COMMUNITY SERVICES DEPARTMENT

October 3, 2022

Subject: Sterling Ranch Filing No. 4 Final Plat – Preliminary Comments (SF-22-030)

STERLING RANCH FILING NO. 4

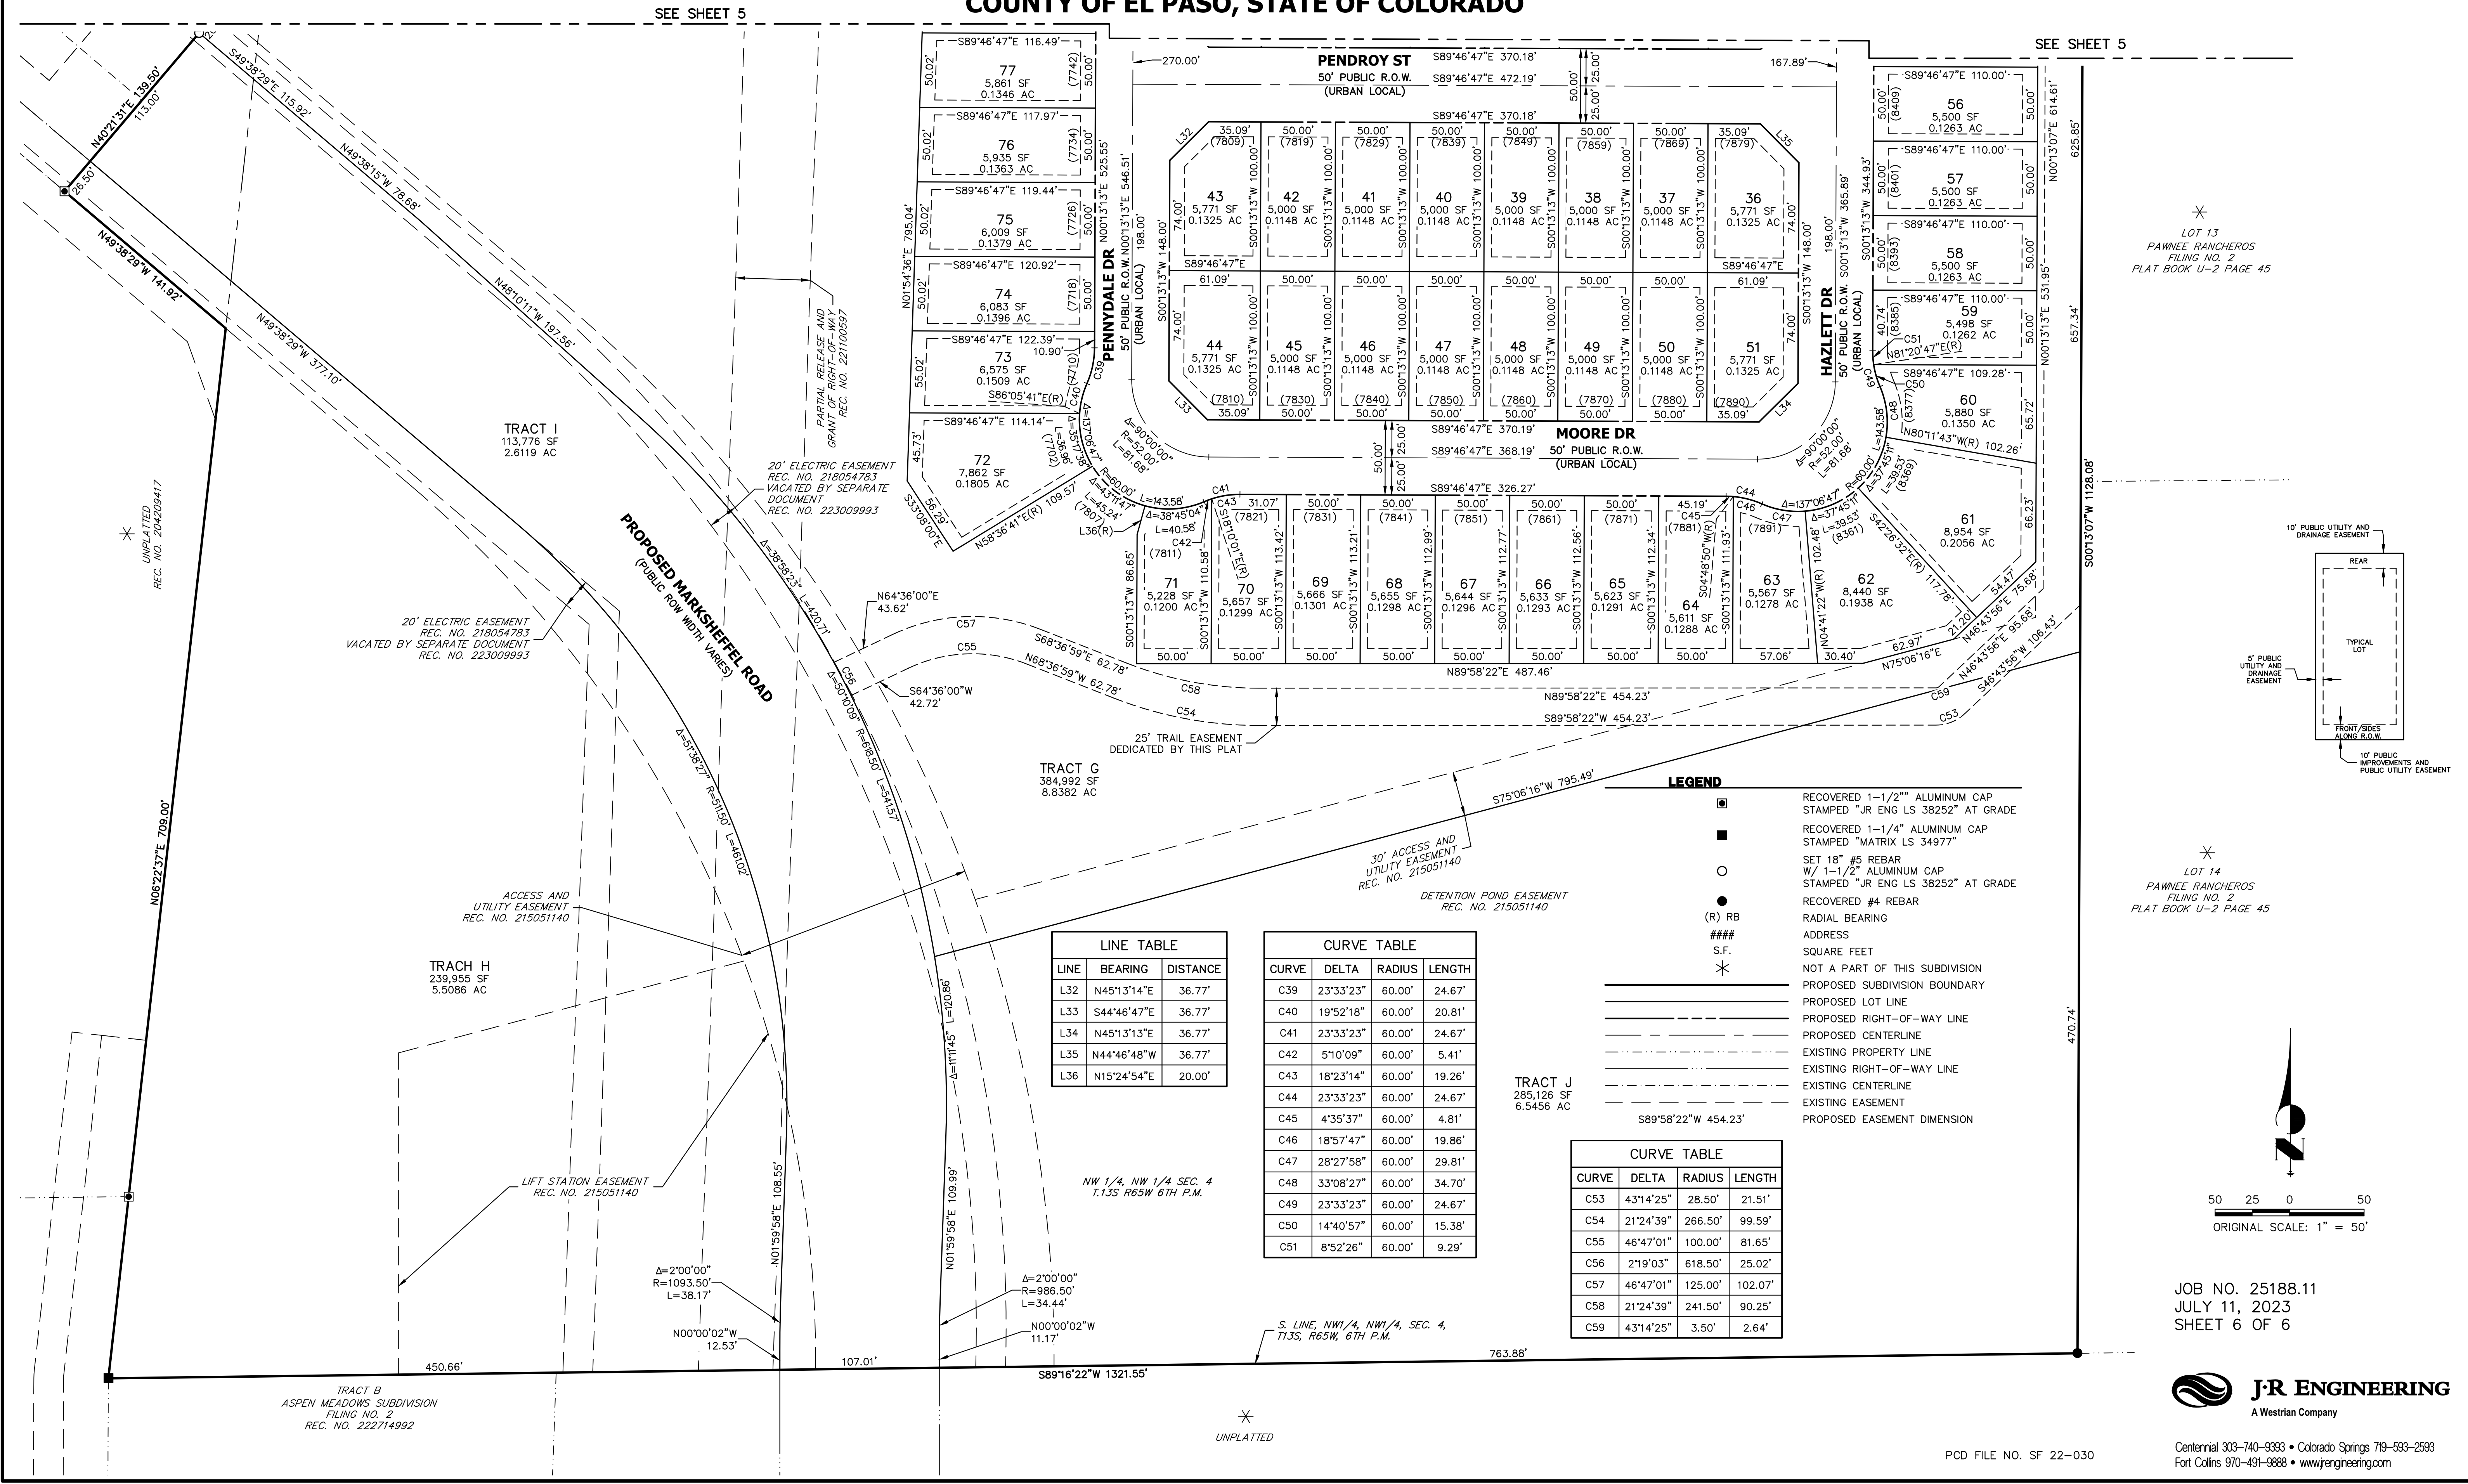
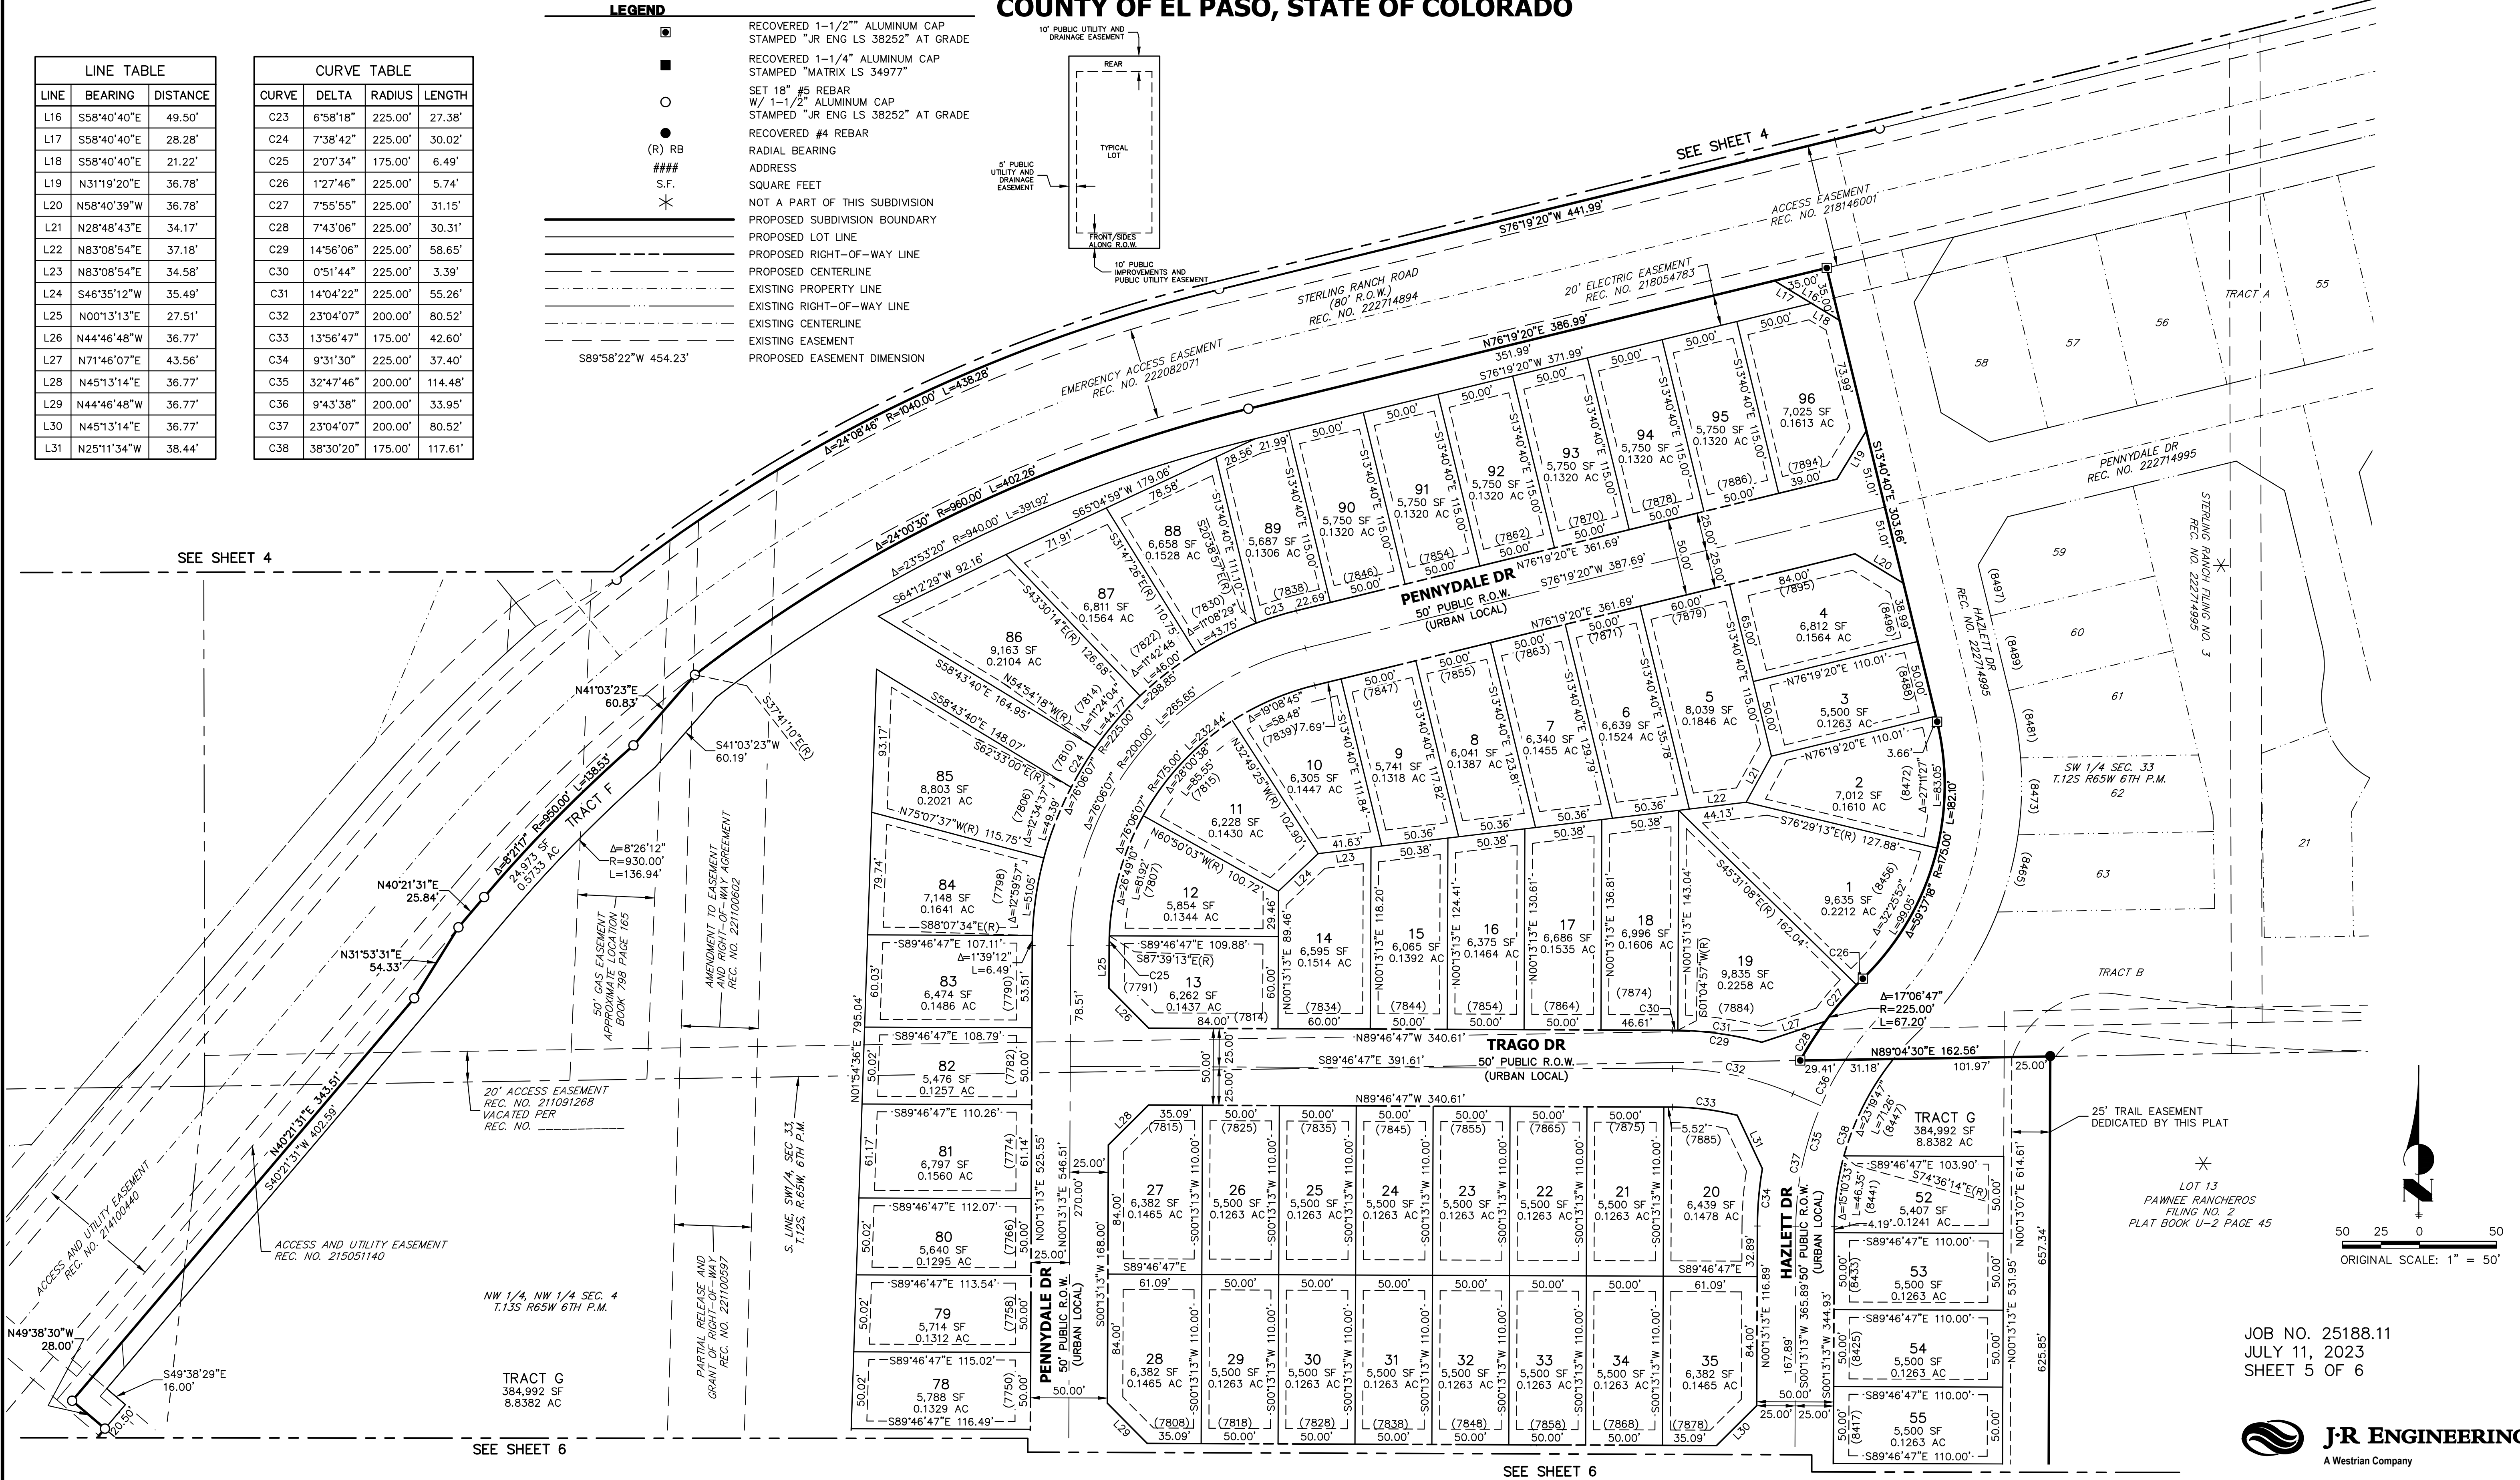
Staff recommends that the developers designate and provide to El Paso County a 25-foot trail easement through Filing No. 4, Tract G, north-south along its southeastern boundary through the existing utility corridor, then east-west past the planned stormwater detention facility to its terminus at Marksheffel Road, that allows for public access, as well as construction and maintenance of the Sand Creek Regional Trail. Furthermore, staff recommends fees in lieu of land dedication for regional and urban park purposes due upon recording of the Final Plat.

The Park Advisory Board recommends that the Planning Commission and the Board of County Commissioners include the following conditions when considering and/or approving Sterling Ranch Filing No. 4 Final Plat: (1) show on this Final Plat and dedicate to El Paso County a 25-foot trail easement through Filing No. 4, Tract G, north-south along its southeastern boundary through the existing utility corridor, then east-west past the planned stormwater detention facility to its terminus at Marksheffel Road, that allows for public access, as well as construction and maintenance of the Sand Creek Regional Trail; (2) require fees in lieu of land dedication for regional park purposes in the total amount of \$72,220 and urban park purposes in the total amount of \$45,530 due at time of the recording of this Final Plat.
